From: Contact Centre (CRM) <contact@ribblevalley.gov.uk>
Sent: 07 May 2022 12:33
To: Planning
Subject: Planning Application Comments - 3/2022/0148

Planning Application Reference No.: 3/2022/0148

Address of Development: Black Horse, Pimlico, Clitheroe

Title : Proposed Elevations 1

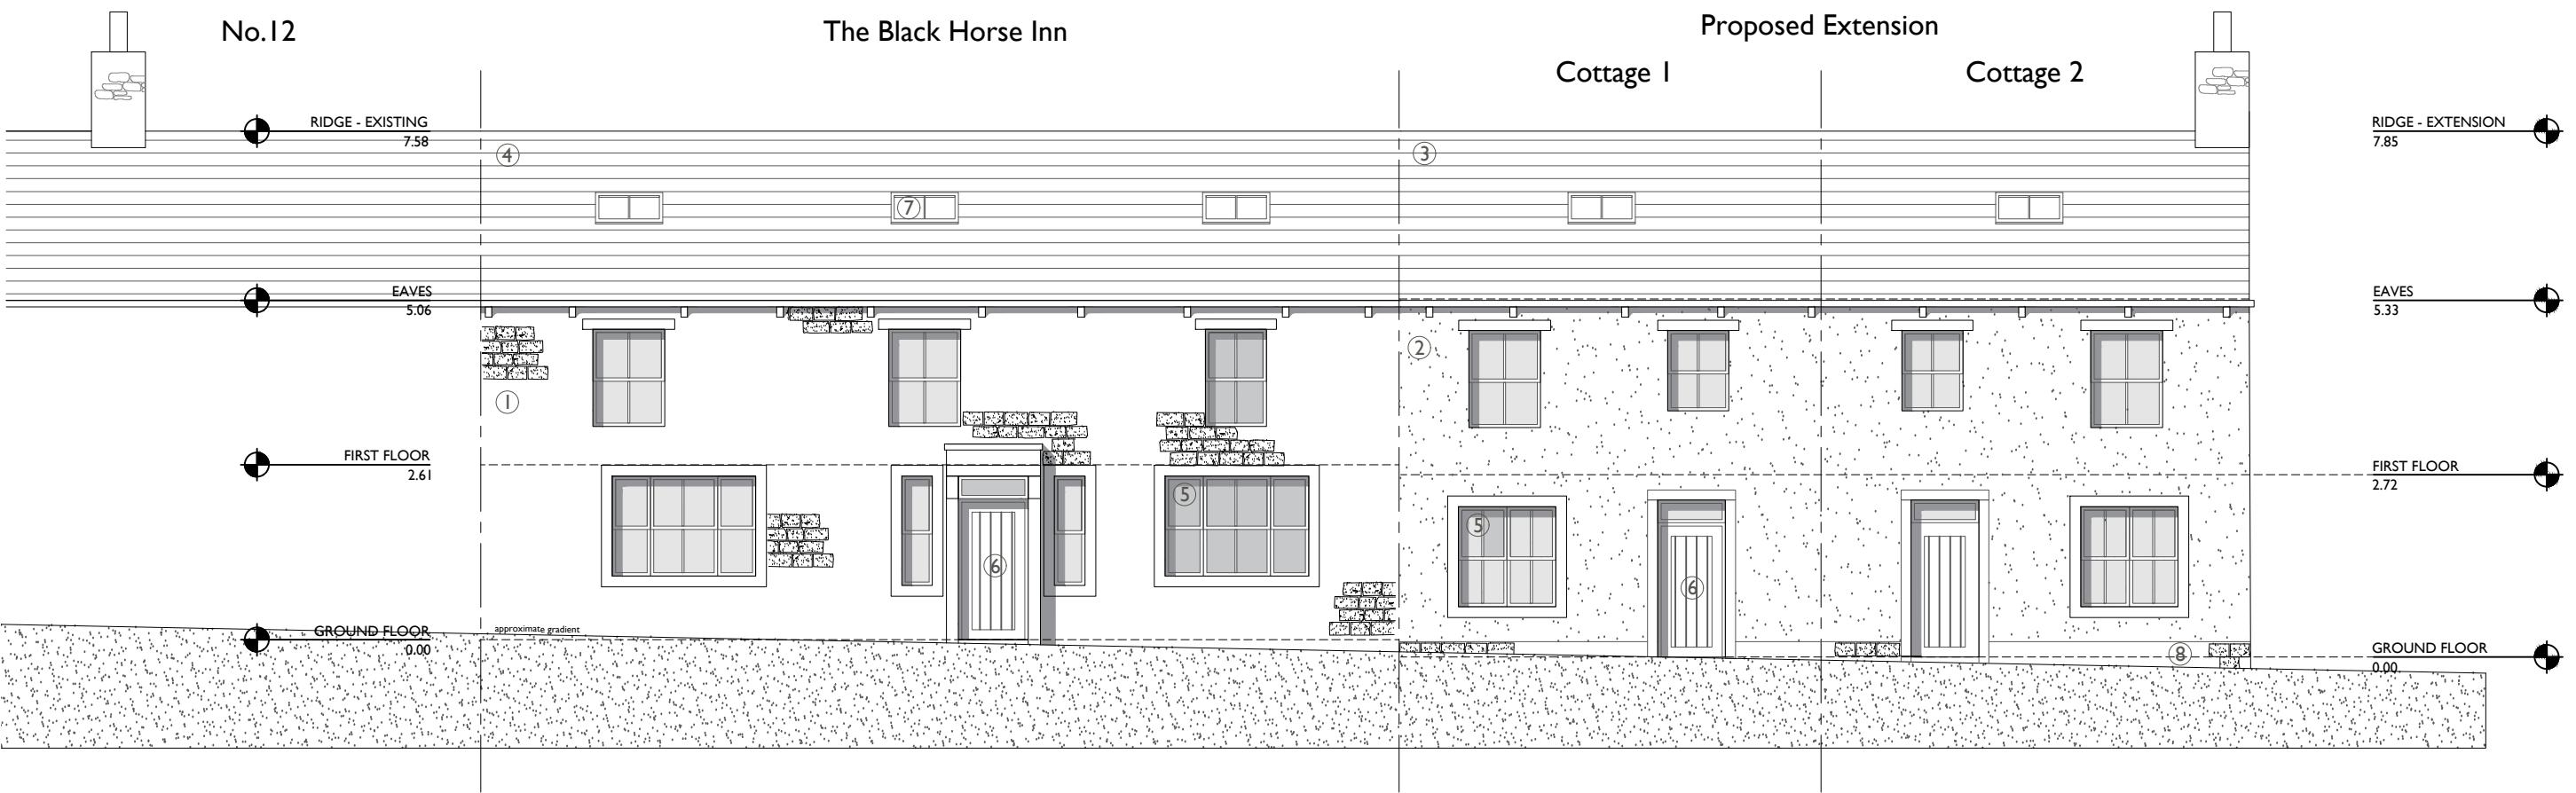
Comments: I submit comments on behalf of Clitheroe Civic Society in respect of this application. The proposed elevations for the two new cottages to be built on to the Black Horse show that extensive white render is the chosen finish for these properties. This is completely at odds with the setting of Pimlico Village and all properties there today have traditional limestone finishes. Use of white render instead of a traditional stone finish will not be conducive to the street scene in this location. Given the historic nature of the properties at Pimlico Village, any development should respect the materials already used. The two new cottages do not do this. Use of white render is also notorious for staining even if sufficient eaves depth is delivered. The use of white render for these properties (particularly to the front/side elevations) is incongruous and should be re-thought before this application is approved. Even render coatings that promise many years of service still stain in westerly locations due to the higher levels of humidity and algal growth - this is still the case even where manufacturers promise algae free finishes - our damp climate is not suitable especially where the finish would face a prominent location and entry point into the town. The proposed finishes would be detrimental to the character and setting of the row that makes up Pimlico Village. As the dimensions of the cottages look to respect the dimensions and traditional nature of the row, so should the finish.
